**Consultation Response from KC,
Trees****2026/91479 63, The Lodge, Linthwaite, Huddersfield, HD7 5TG****Formation of driveway and dropped kerb****Date Responded: 17/06/2026****Responding Officer: JD****Responding Ref:**

Proposed Site Plan

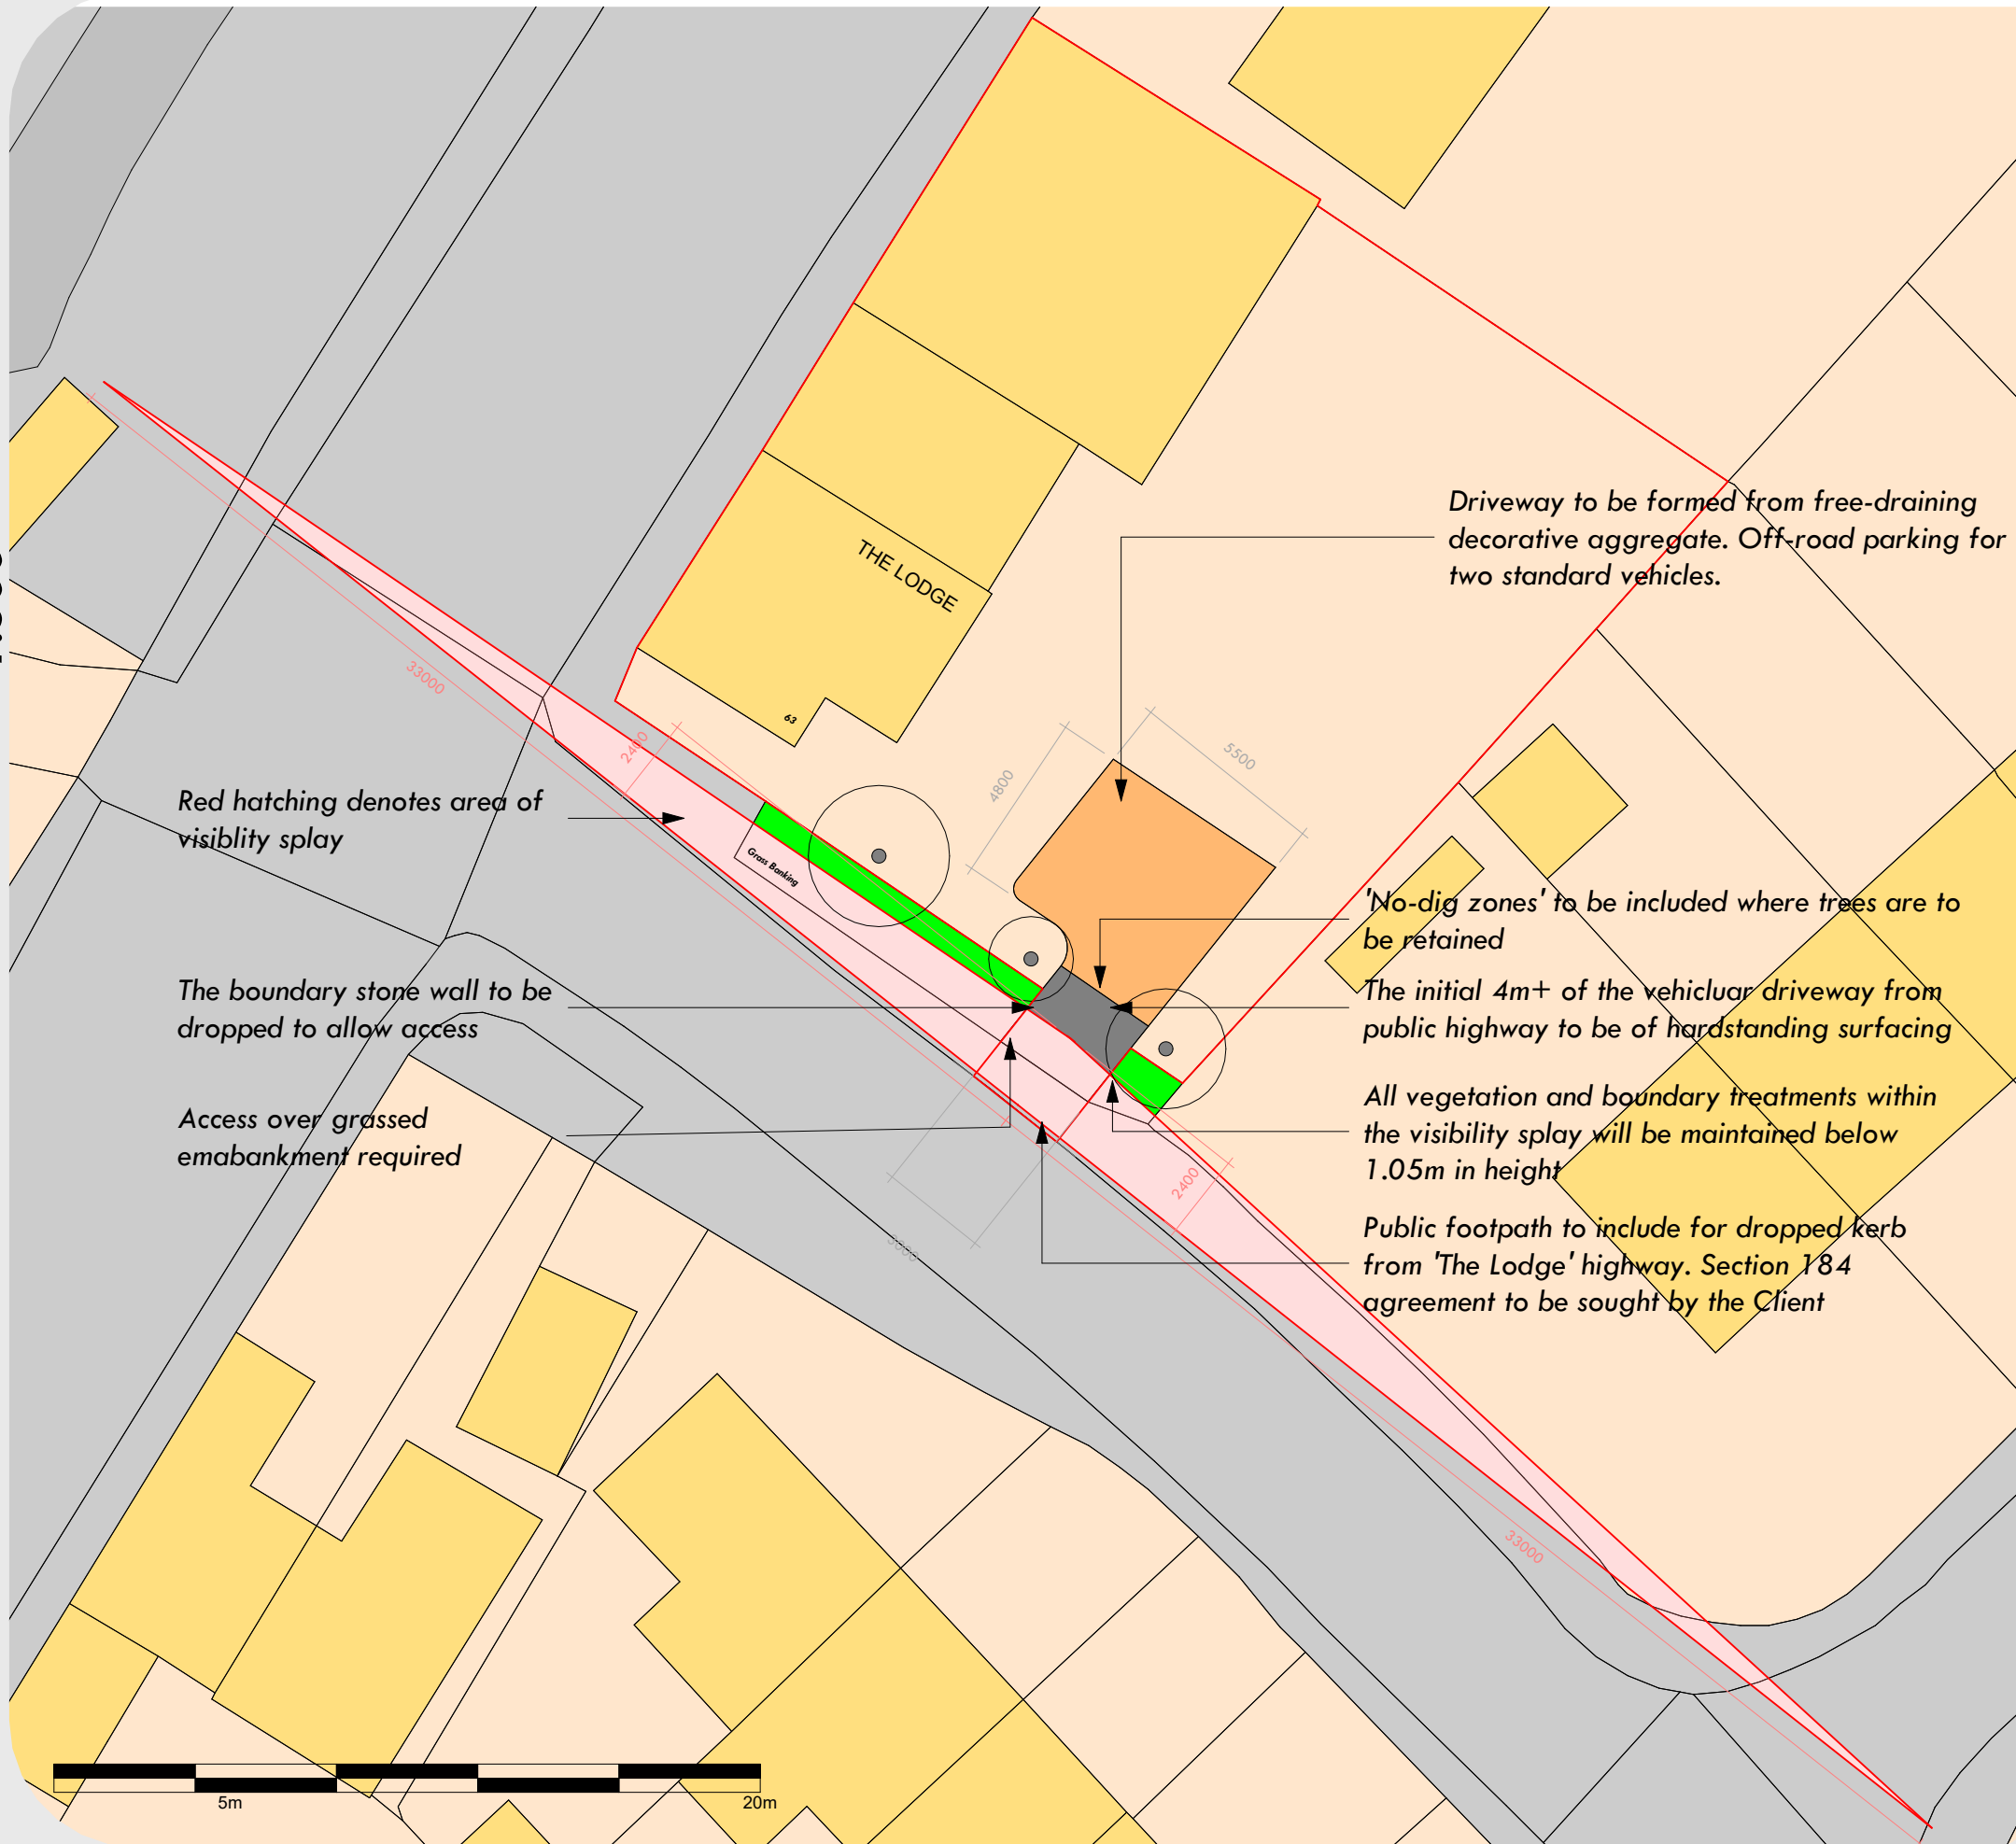
None of the trees located on this site are protected. Of the three trees present in the area for development none would meet the criteria for protection due to their species, location and heavy pruning they have suffered in the past. Therefore their removal to facilitate the proposals would be deemed acceptable.

If the trees are to be retained, then no dig techniques should be implemented and porous materials used for the drive way.
